Date: April 29 2025

File: 073124 - 45 Oak Street

URBAN DESIGN REVIEW PANEL REPORT - 45 OAK STREET

ÉÉP LOUISE-ARBOUR 45 OAK STREET, OTTAWA, ON

SITE

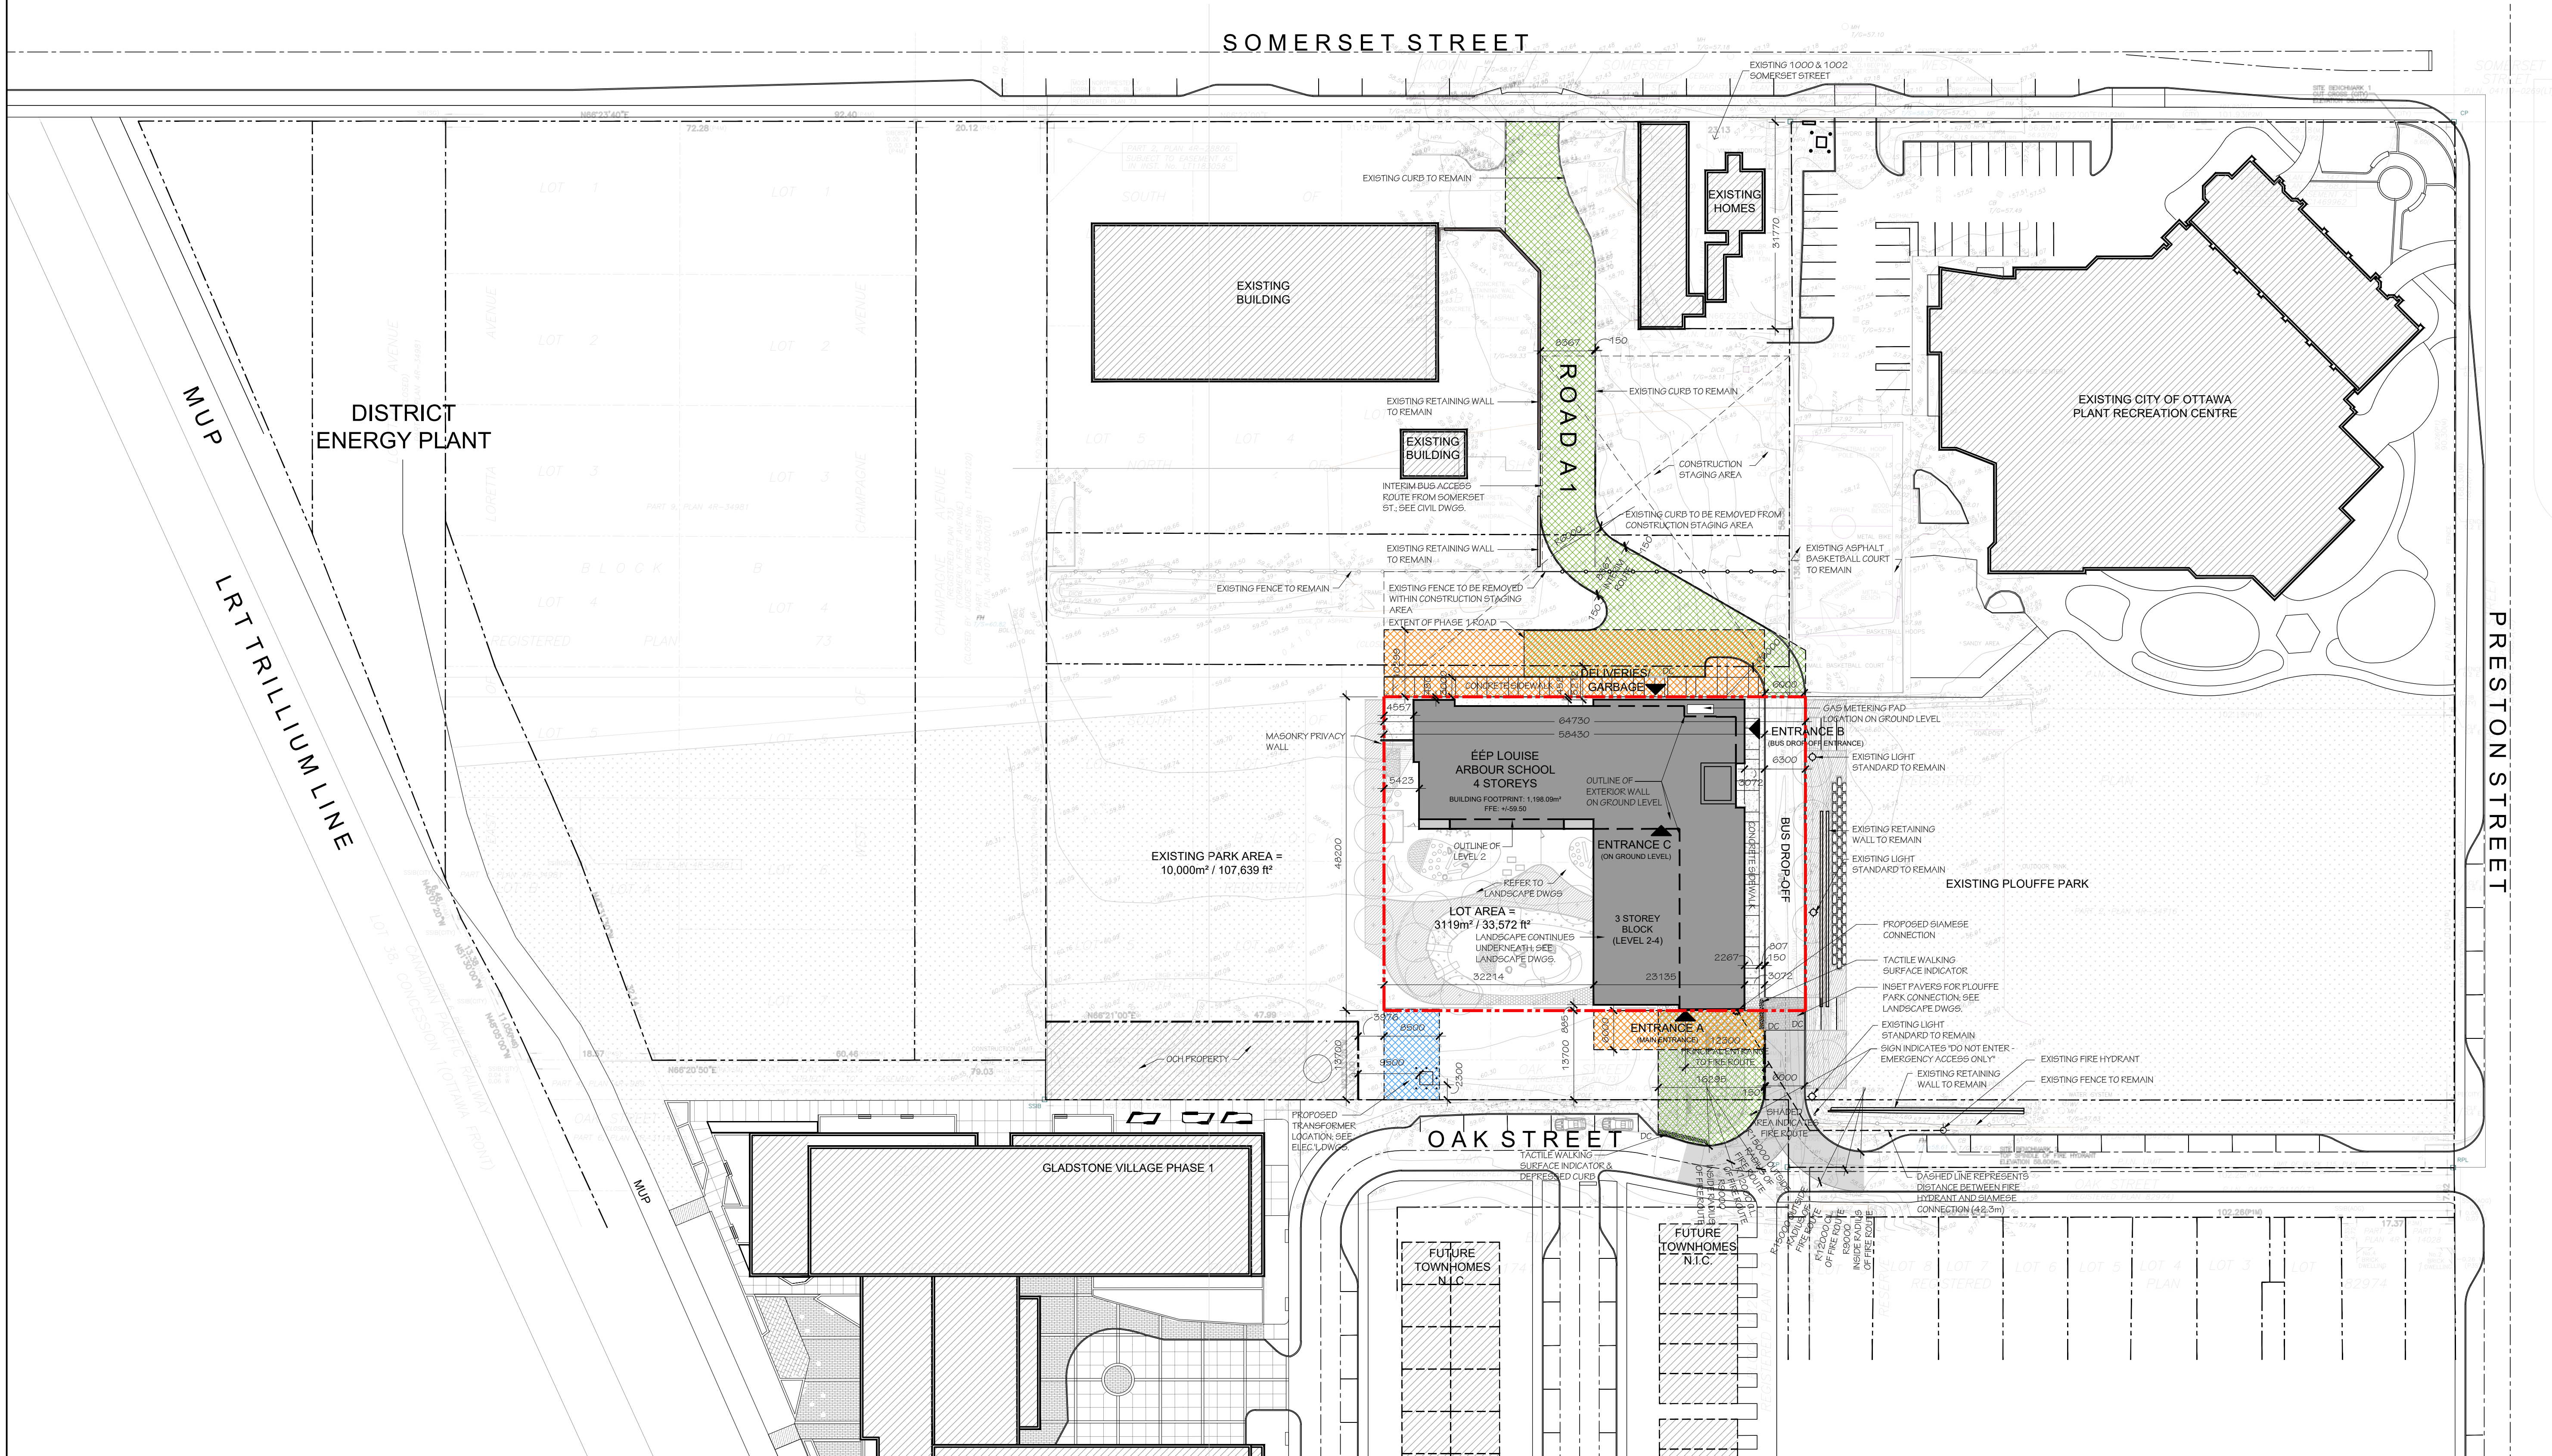
(5 of 25) The Panel raised concerns regarding the school entrance, bus drop-off, and vehicular integration, and encouraged the design team to continue exploring solutions.

- A suggestion was made to consider placing school buses further away from the school to allow for a short walk, referencing traditional school arrival experiences that could benefit the morning routine and enhance the public realm.
- The recommendation is appreciated and various options have been reviewed for the bus route and safe drop off and pick up of students. The proximity of the bus drop off space to the school is important to address safety concerns with primary school-aged children and minimizing the distance they must walk. Further, demarcation of the school bus zone may provide future opportunities for useable amenity space for school and/or park events in off-school times and seasons.

(13 of 25) The Panel has concerns with having the school surrounded by roads on three sides and recommends considering future phasing options to improve school connectivity and reduce vehicular adjacency for children safety.

(14 of 25) The Panel supports a thoughtful approach to border conditions and stresses the need for safe and seamless connections between the school, adjacent streets, and the park.

While the area to the north of school is traversable, it will not be a heavily trafficked area and further, it is not a main entrance for student use and as such will not be a factor for conflicts with students and vehicles at this location. The bus route on the east side of the school is for bus traffic only and will not be used by regular vehicles. It will be controlled specifically for student safety. When bus activity is absent, the section for bus drop off will function as a pedestrian connection to Plouffe Park. Some form of control will be in place to prevent vehicles from driving into the section of bus lane directly east of the school. Further, Oak Street to the south is separated from the school by a section of City park land that will create a suitable buffer during before and after school pickups and drop-offs. While there are roads in place around the school, their functions and the school entrances for students are designed in such a manner that conflict for students will be extremely minimal.

Safety is always a primary consideration in the planning of school site and the position of sidewalks and connections to the park and the rest of the hub and surrounding neighbourhoods. The connections through the hub and around the school are designed to facilitate easy connectivity and design with the future park designs. Both planning teams will continue to work with staff moving forward to ensure that the area is designed and coordinated with seamless integration of design in mind.
